From: THERESA WOODWARD [REDACTED]
Sent: 18 May 2022 09:33
To: Kathryn Welch <Kathryn.Welch@arun.gov.uk>
Subject: Re: West House Planning application EP/35/22/HH Objection

I am writing to object to planning application EP/35/22/HH

S ELEV

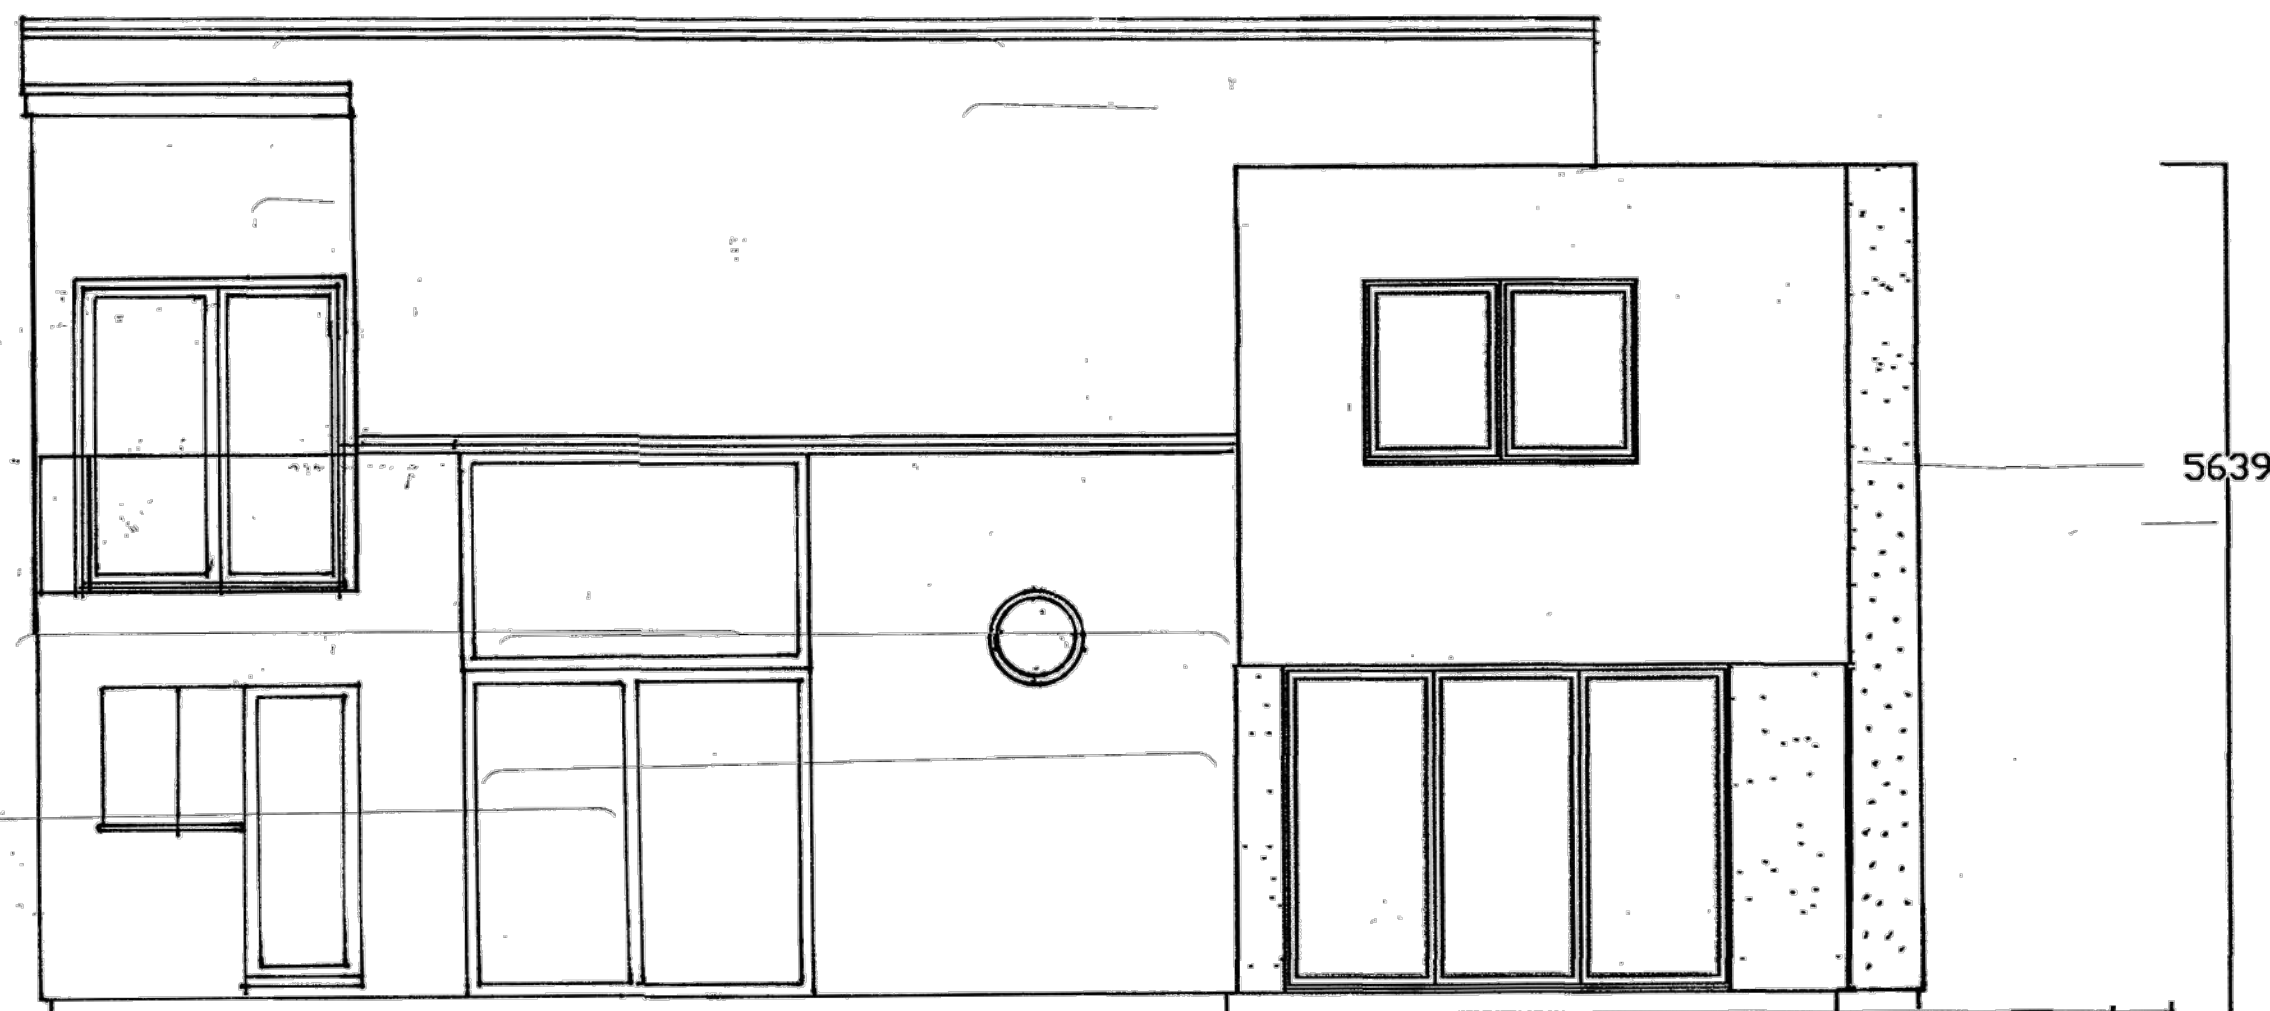
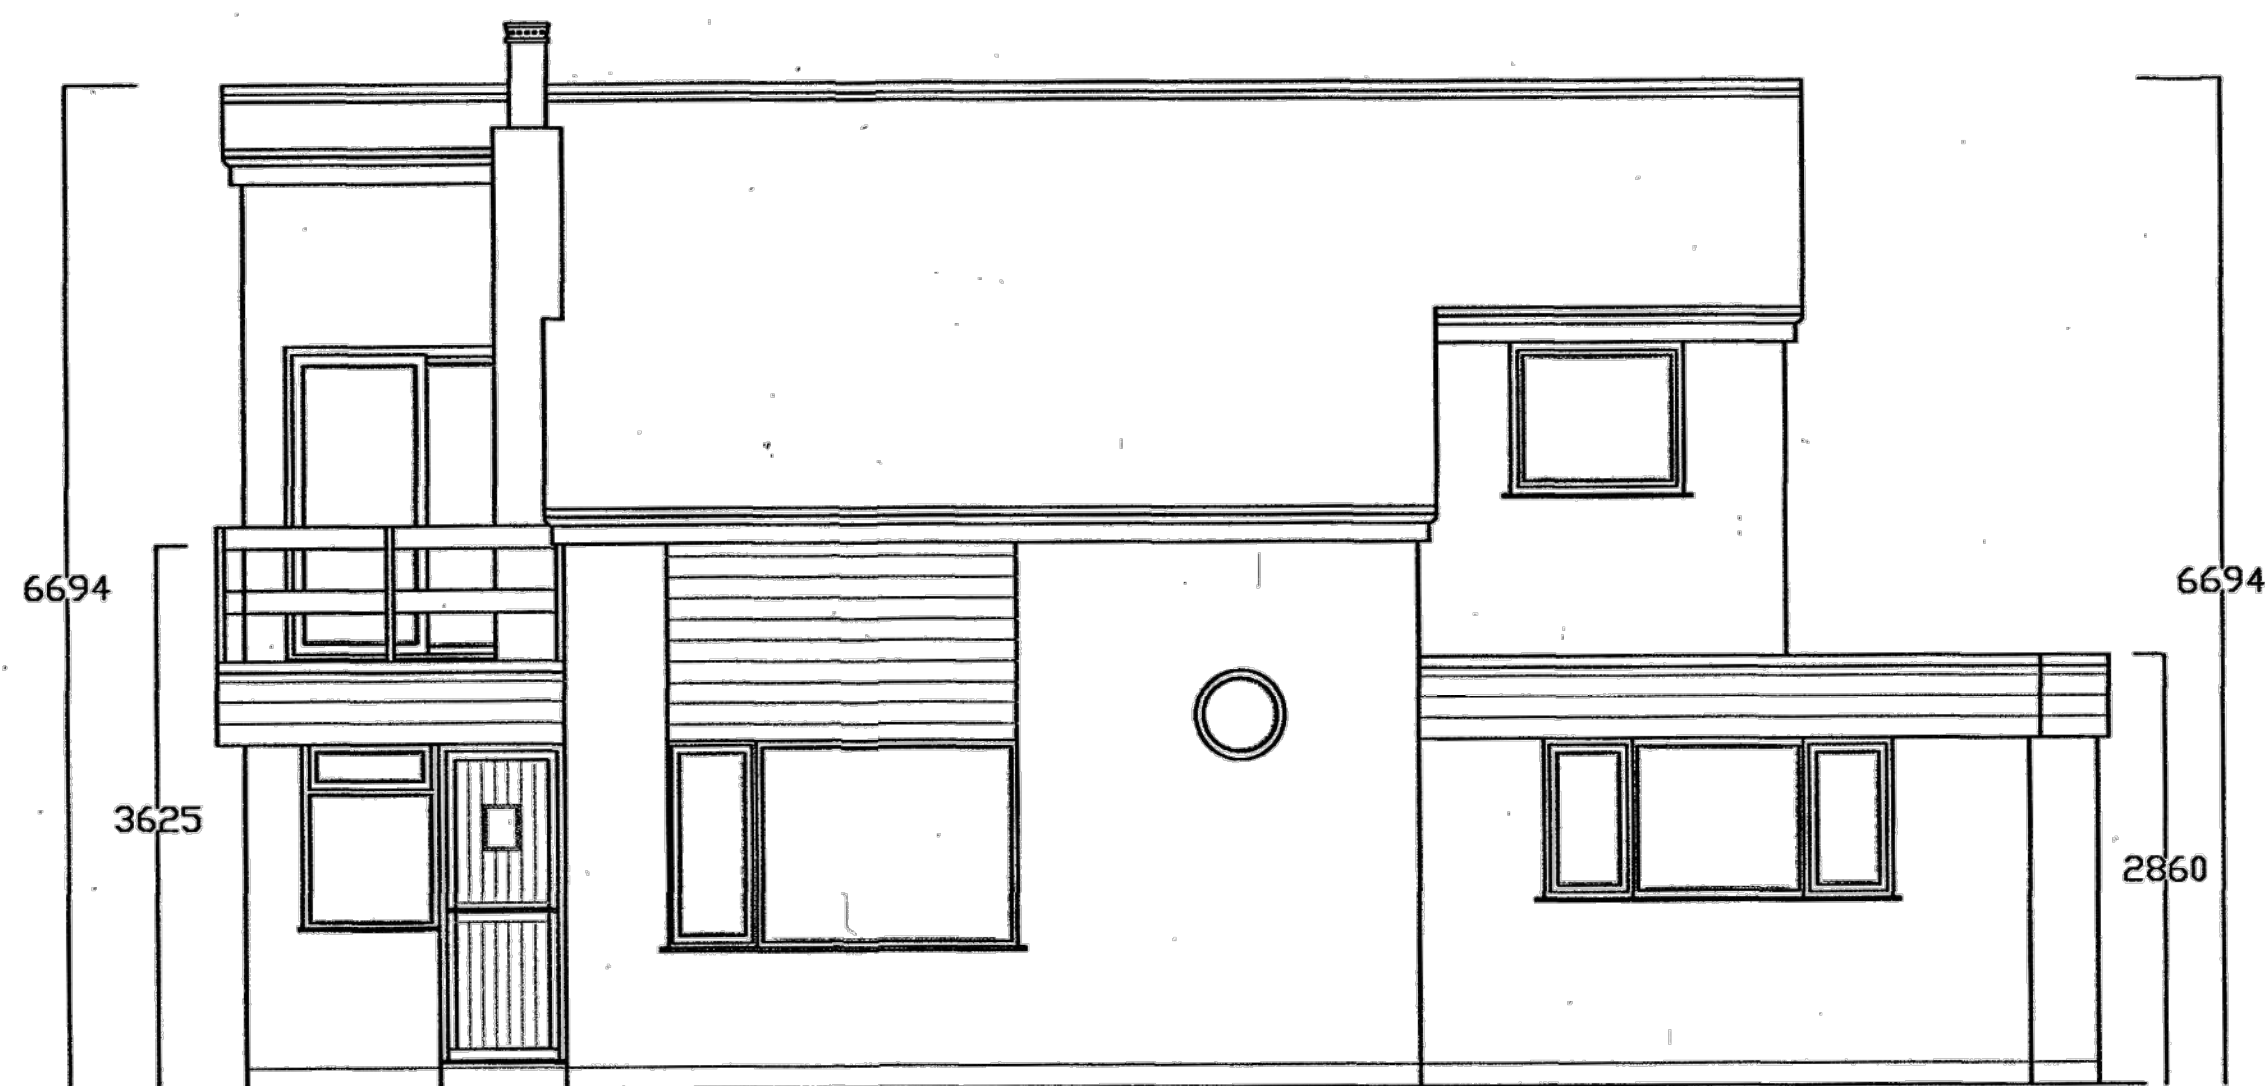
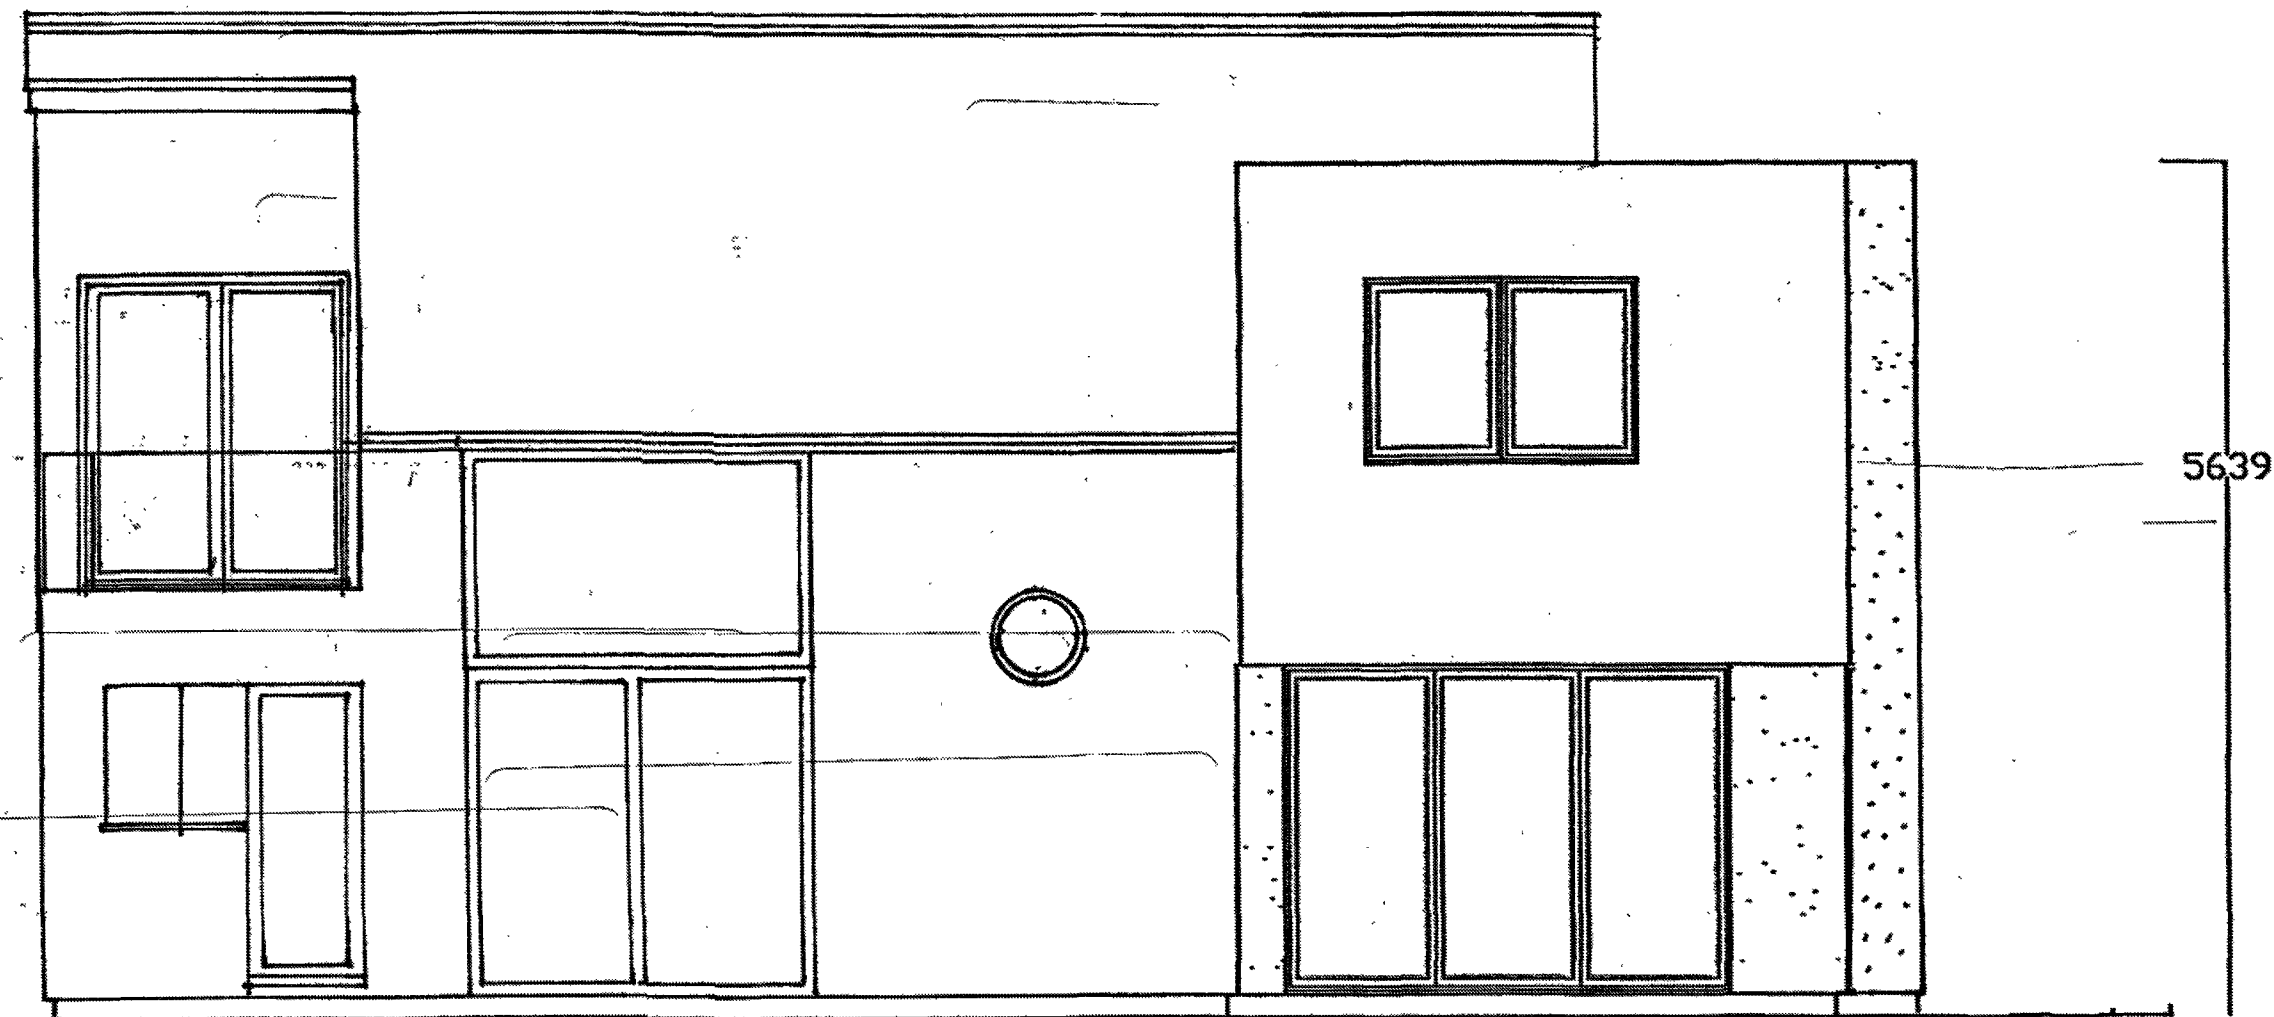
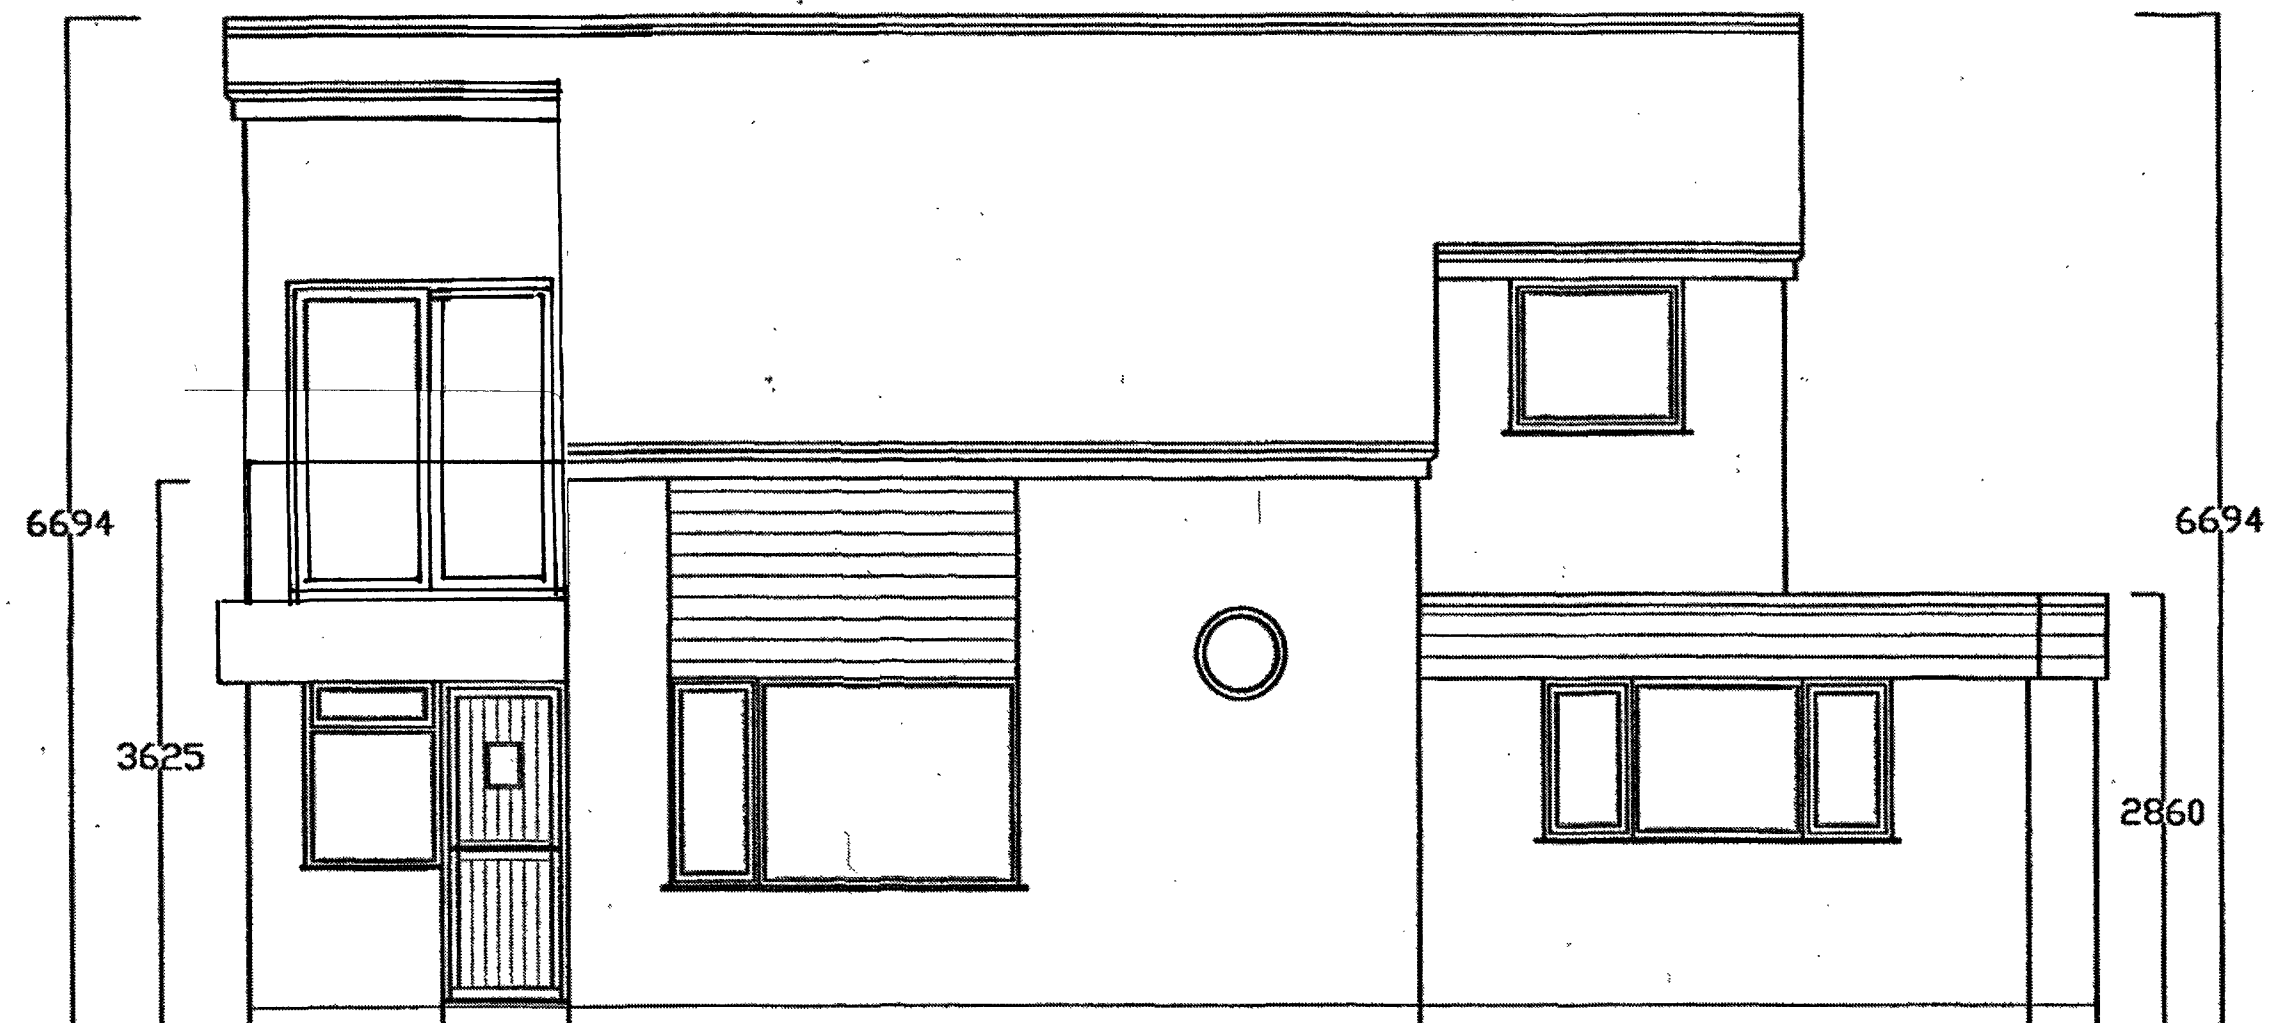
The wooden balcony used to obscure at least 50% of the view and now with clear glass by its nature West House have a clear view into my property, garden, driveway, garage , front habitable rooms - even when they are sitting down, together with views of my neighbours properties driveway and garages.

I am also concerned with the large proposed glass installation above the door at the rear of the property together with a bedroom window which again will look directly into my property.

I would respectfully ask that if this application or a revised version of it is considered that the glass is changed to 1.7 and obscured for the existing balcony. New/replacement glazing installed is opaque and fixed shut on southern elevation.
